**Kemps Creek Warehouse, Logistics and Industrial Facilities Hub Mod 3 (SSD-9522-Mod-3)
Request for additional information**

I refer to the Modification Report for the Kemps Creek Warehouse, Logistics and Industrial Facilities Hub (SSD-9522-Mod-3). The Department is requesting that you provide additional information.

Attachment 1

DRAWING TITLE
Warehouse 2 Floor Plan
DRAWING NUMBER
SP-KC1-DA - 102 -
V

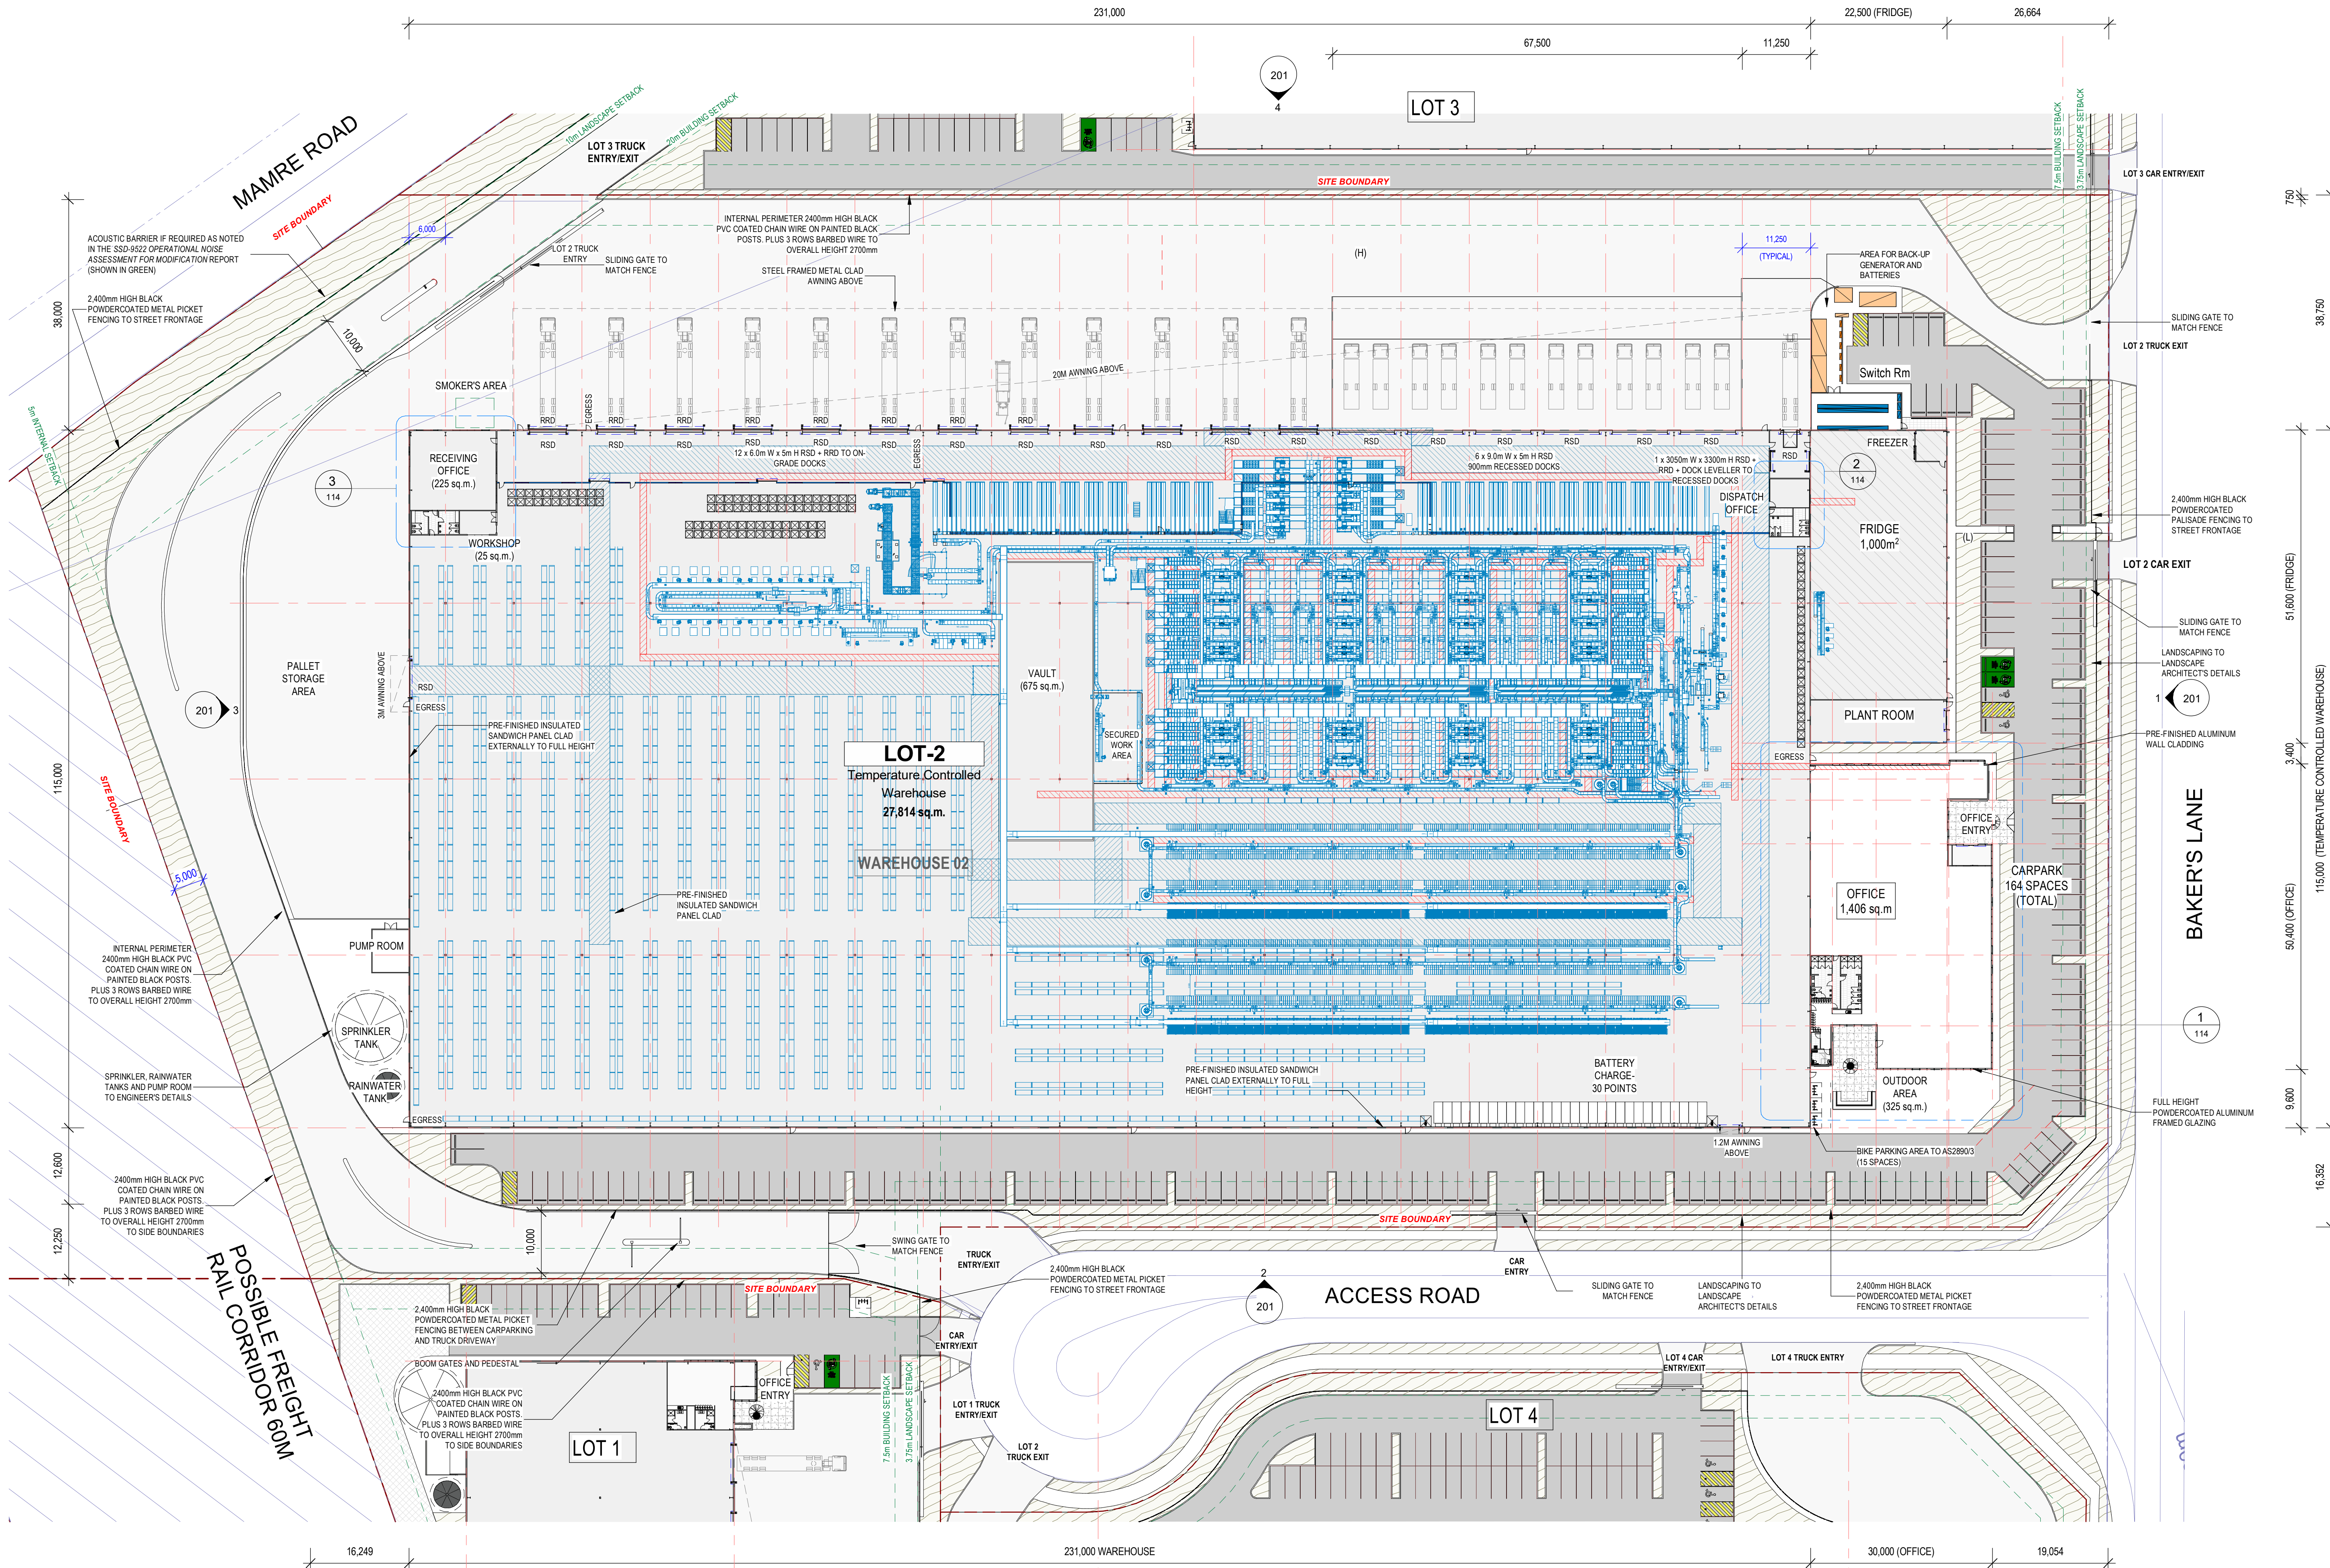
- The Department notes that the gas cylinder storage area for Warehouse 2, shown in Figure 4.3 of the SEPP 33 Assessment (Appendix K), is located next to the smoker's area identified on the Warehouse 2 Floor Plan (SP-KC1-DA-102-P). Please clarify if this poses any safety risks.

LOT-3 DEVELOPMENT TABLE	
SITE AREA	25,403 sqm
EFFICIENCY	41.9 %
WAREHOUSE	10,145 sq.m.
OFFICE (1-LEVEL)	506 sq.m.
TOTAL BUILDING AREA	10,651 sqm
CAR PARKING PROVIDED	47 Spaces
AWNING (15M)	850 sqm
AWNING (5M)	58 sqm
HEAVY DUTY PAVEMENT (H)	5,262 sqm
LIGHT DUTY PAVEMENT (L)	2,462 sqm

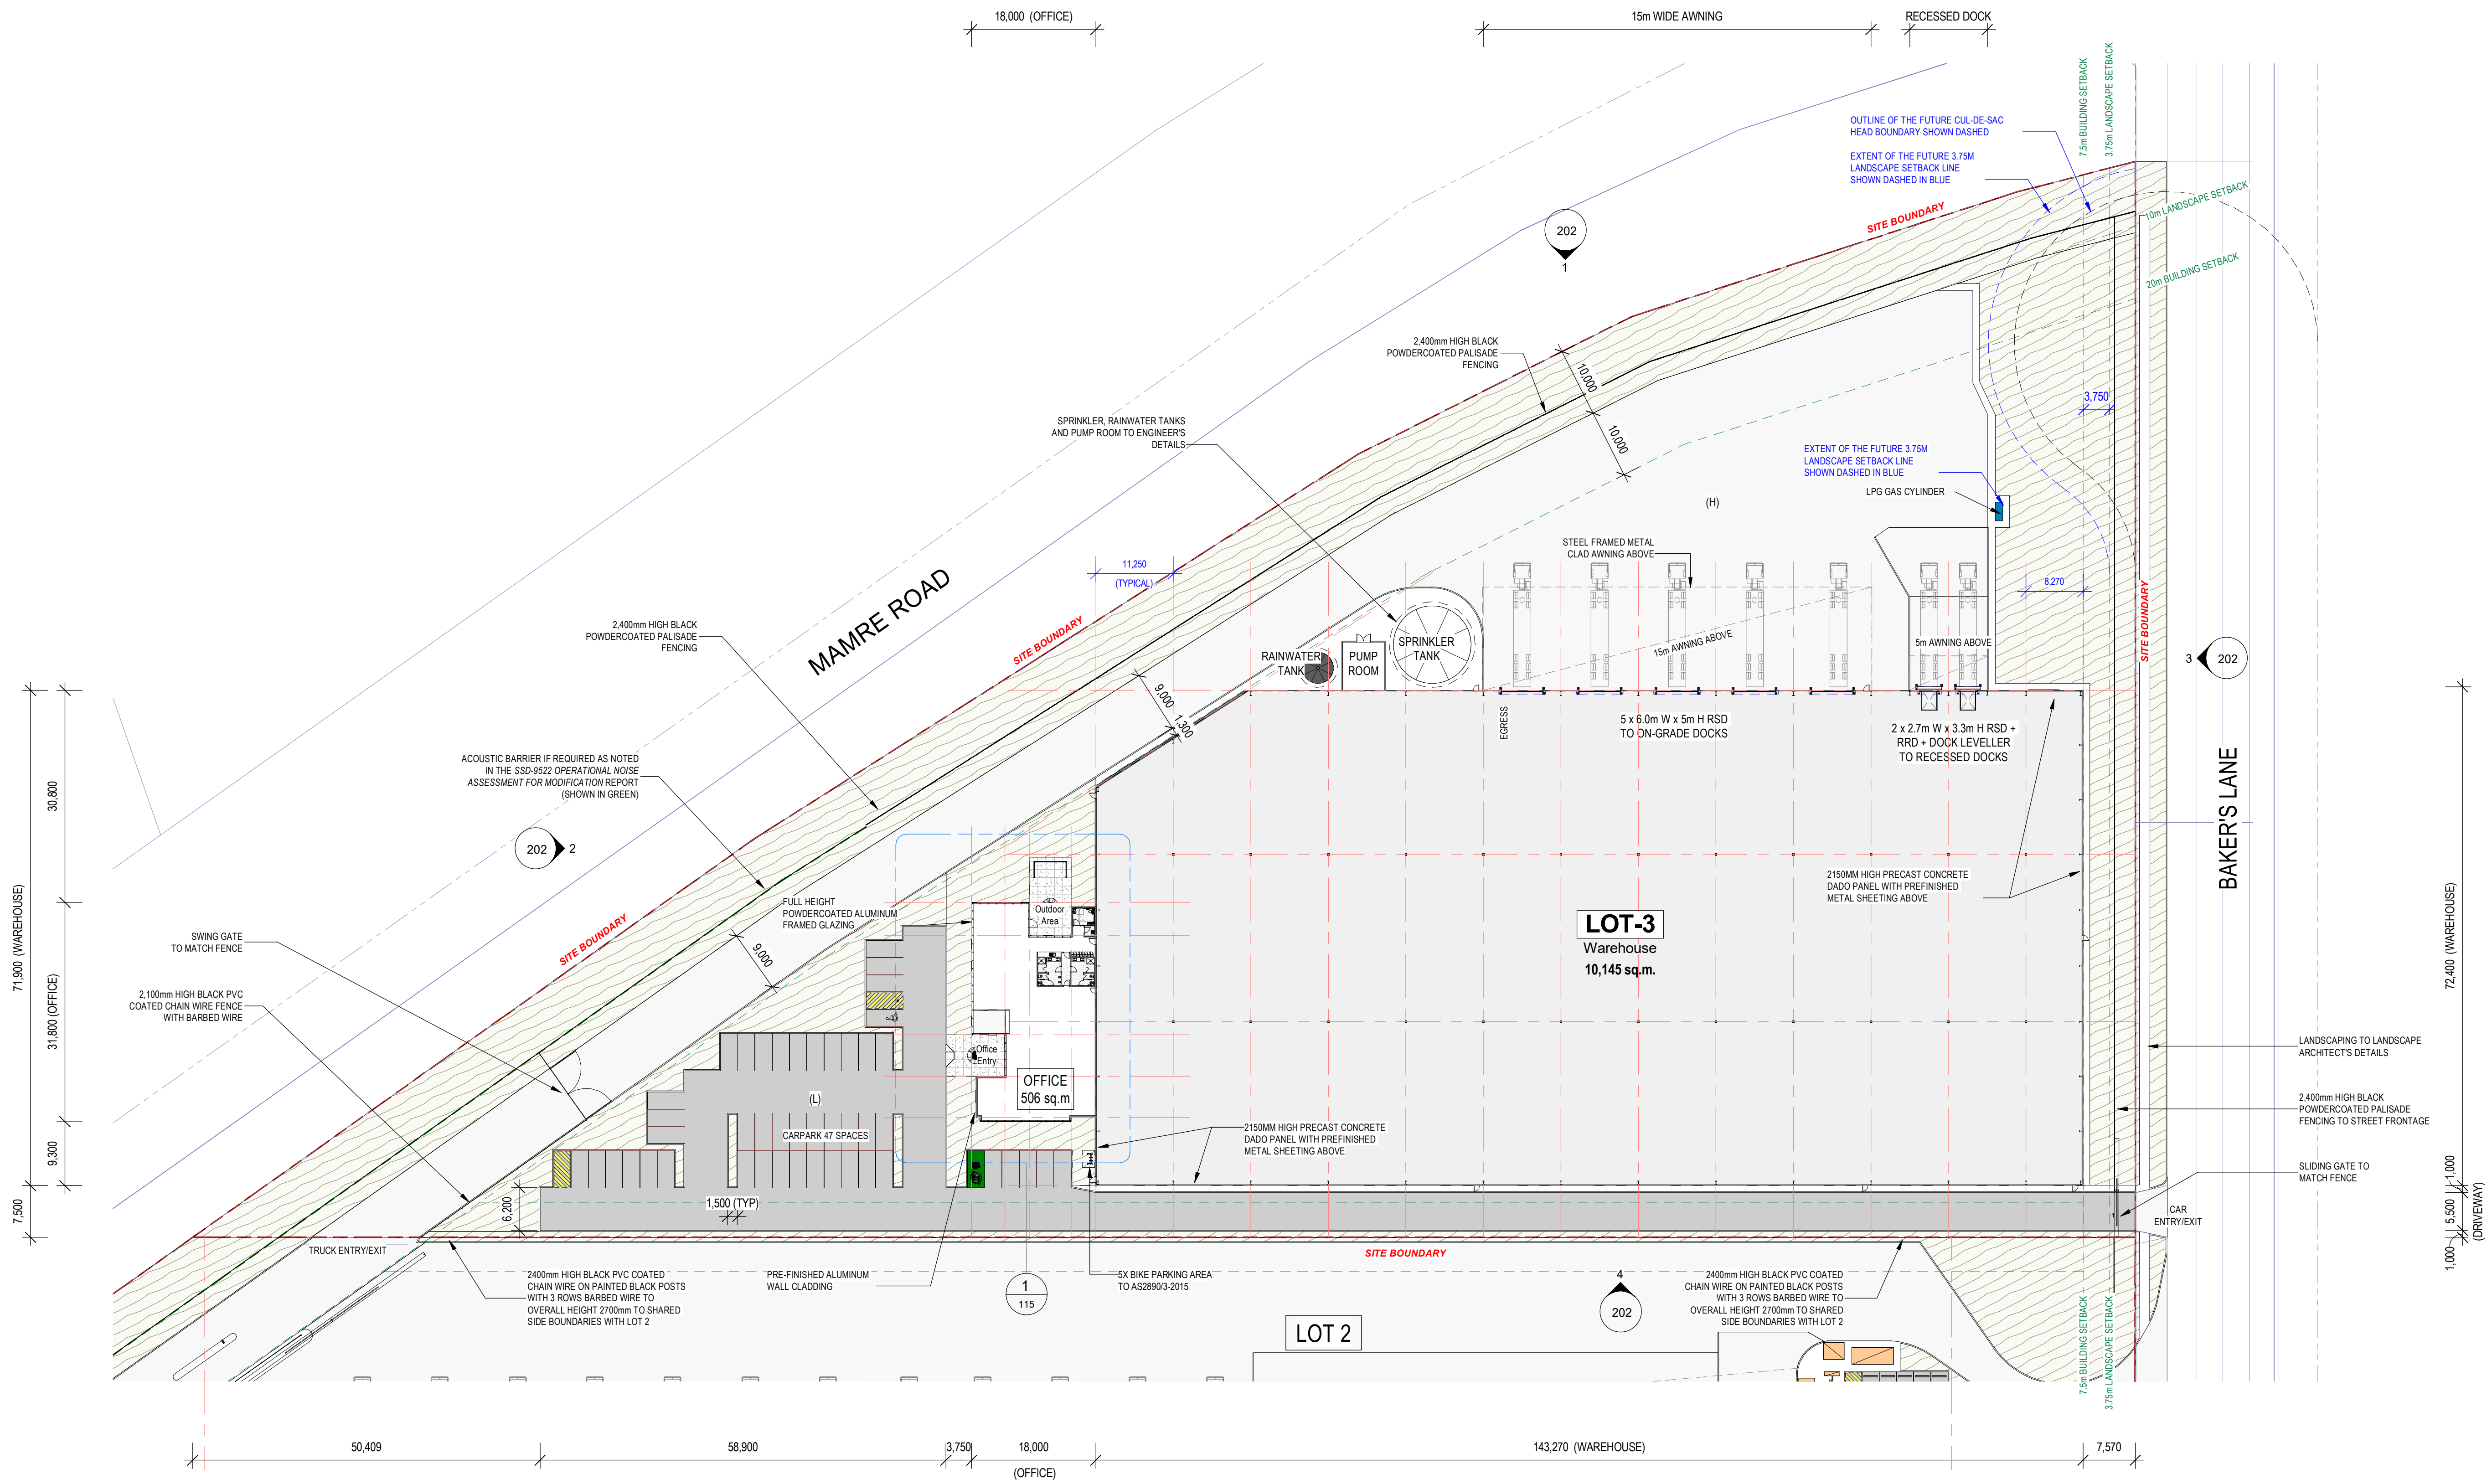
The gas cylinder storage area for Warehouse 3, shown in Figure 4.5 of the SEPP 33 Assessment, should be located outside of the landscaped area.

1 Site Facilities Plan (Lot4)
1: 500 @B1

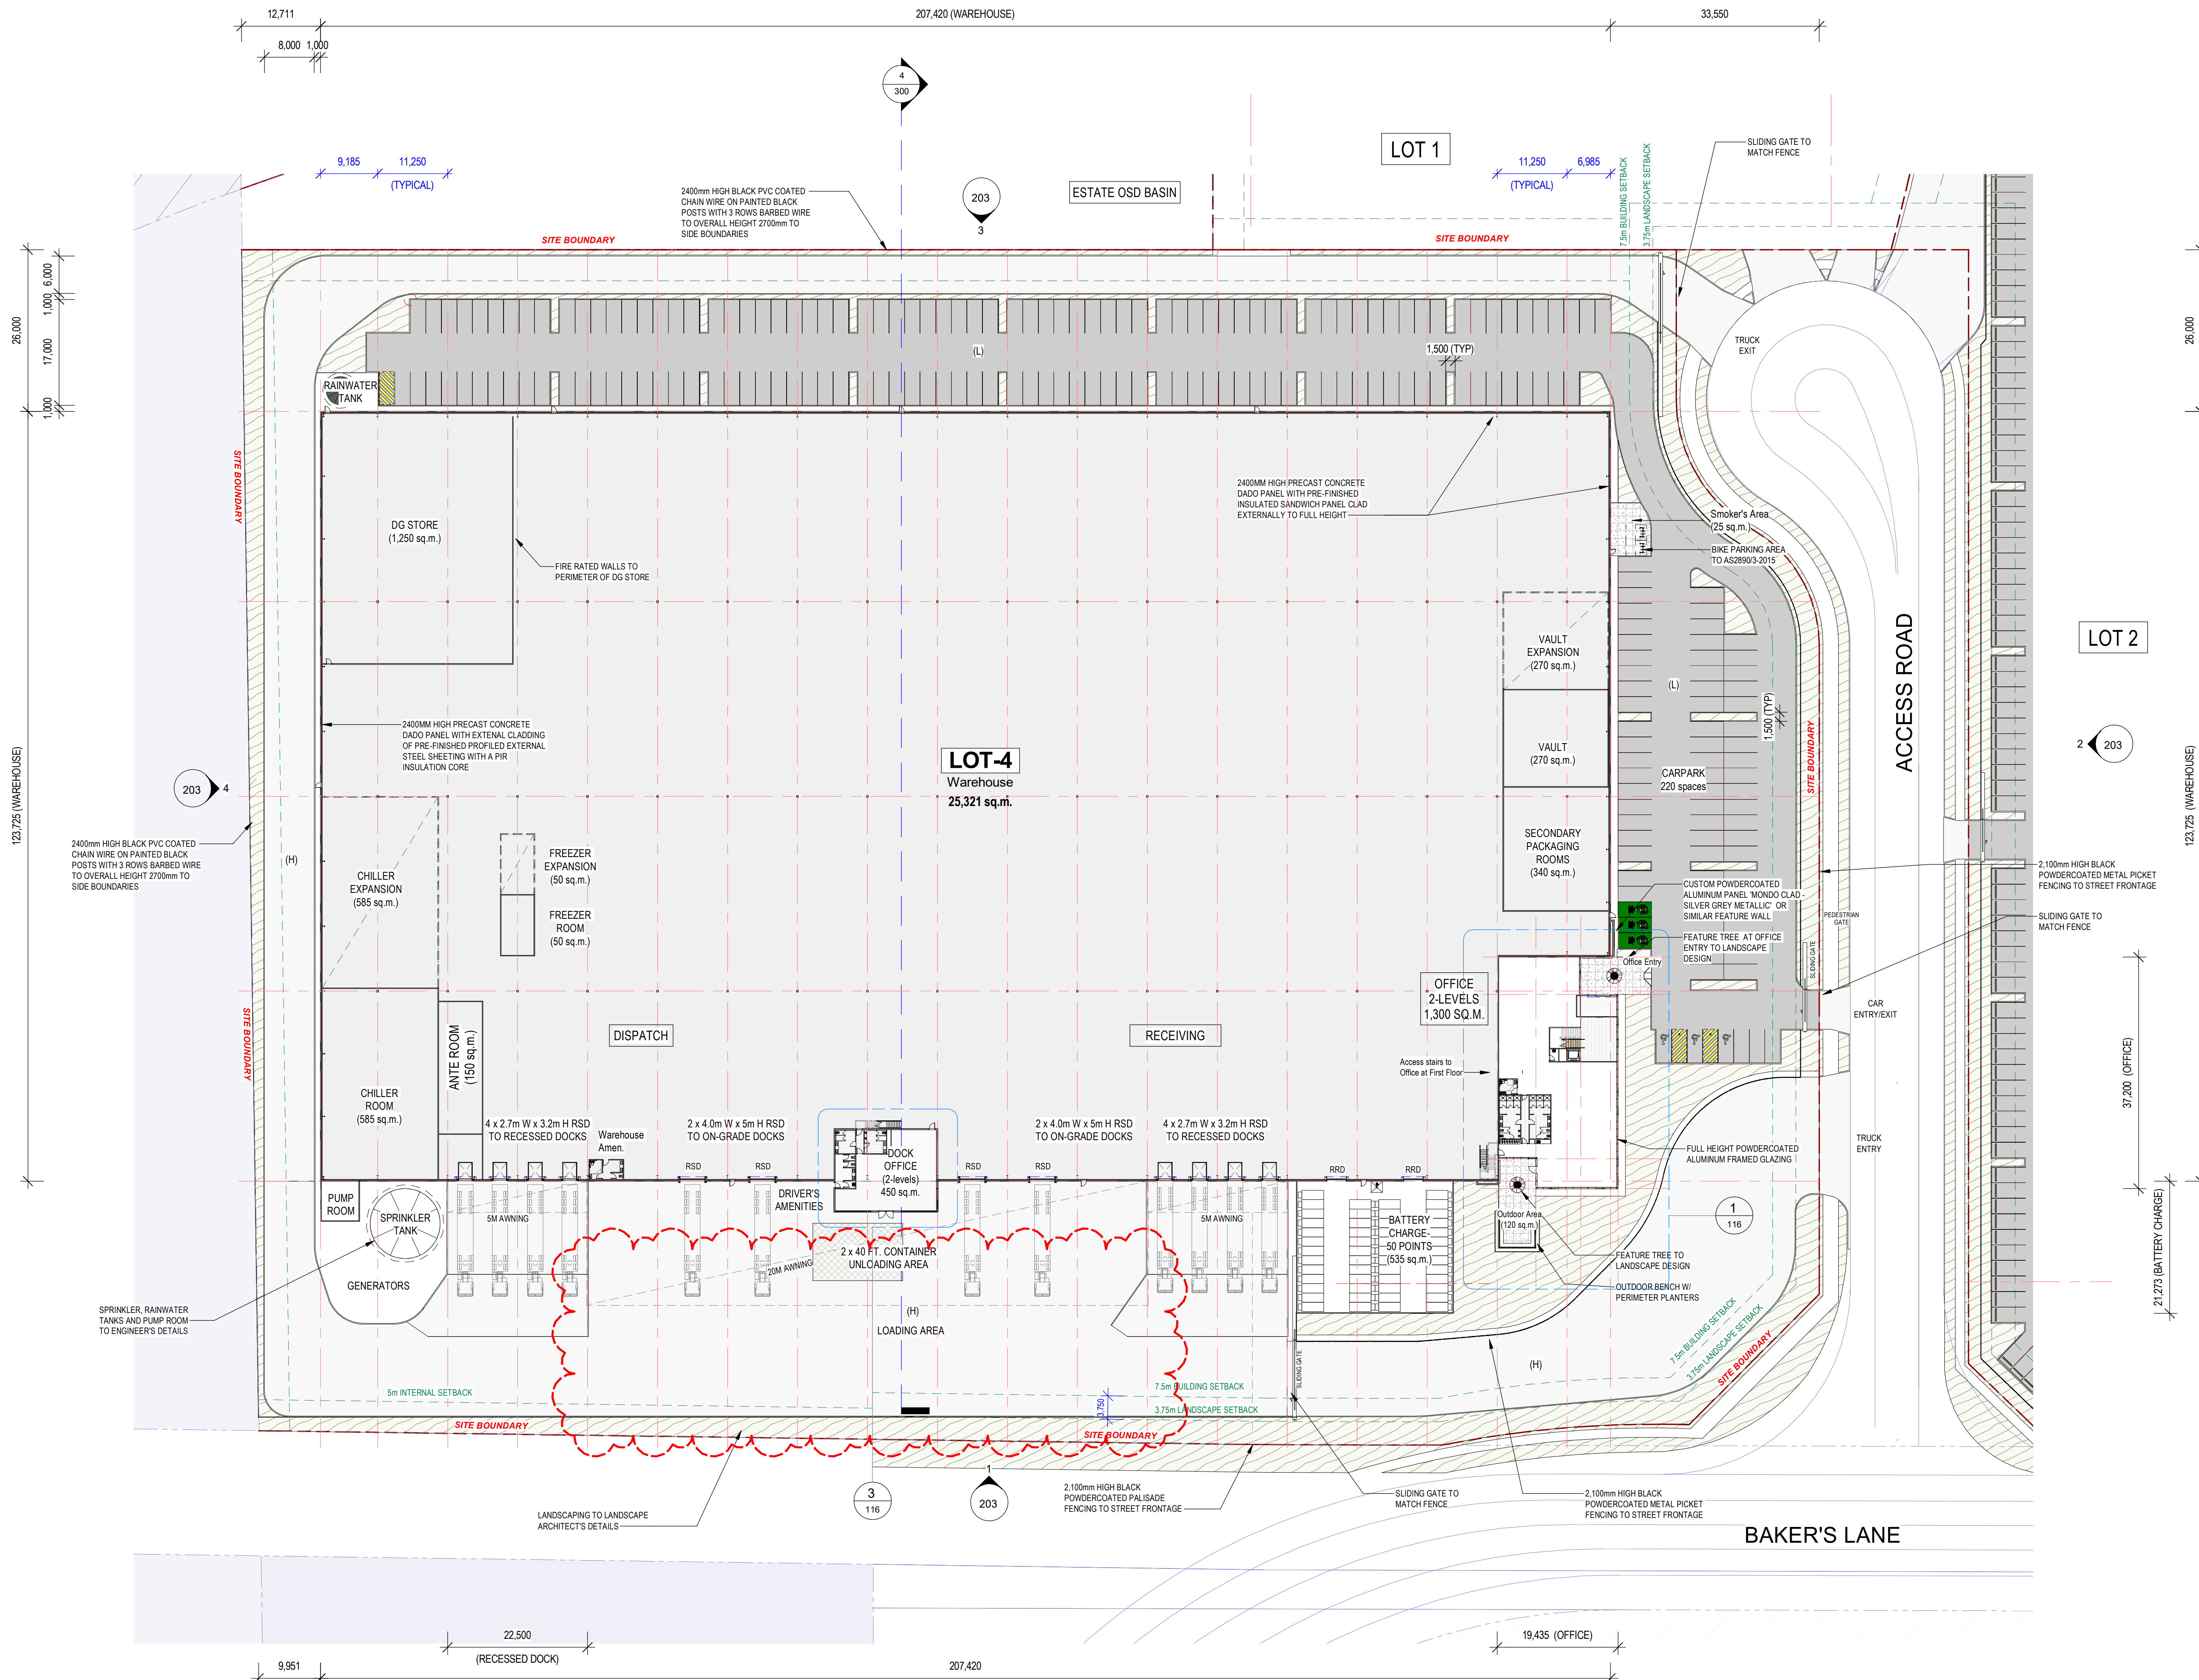
- The 7.5 m building setback to Bakers Lane should be extended along the entire southern boundary of Lot 4 as it fronts the Bakers Lane road reserve, rather than changing to 5 m approximately halfway along.

- Please provide details on the location, size and intended use of the generators proposed for Lot 2 and Lot 4.
- The Department notes that the air quality assessment (Appendix L) considers the inclusion of generators on Lot 2. However, it does not consider the generators for Lot 4 that are identified in the Warehouse 4 Floor Plan (SP-KC1-DA-104-P).
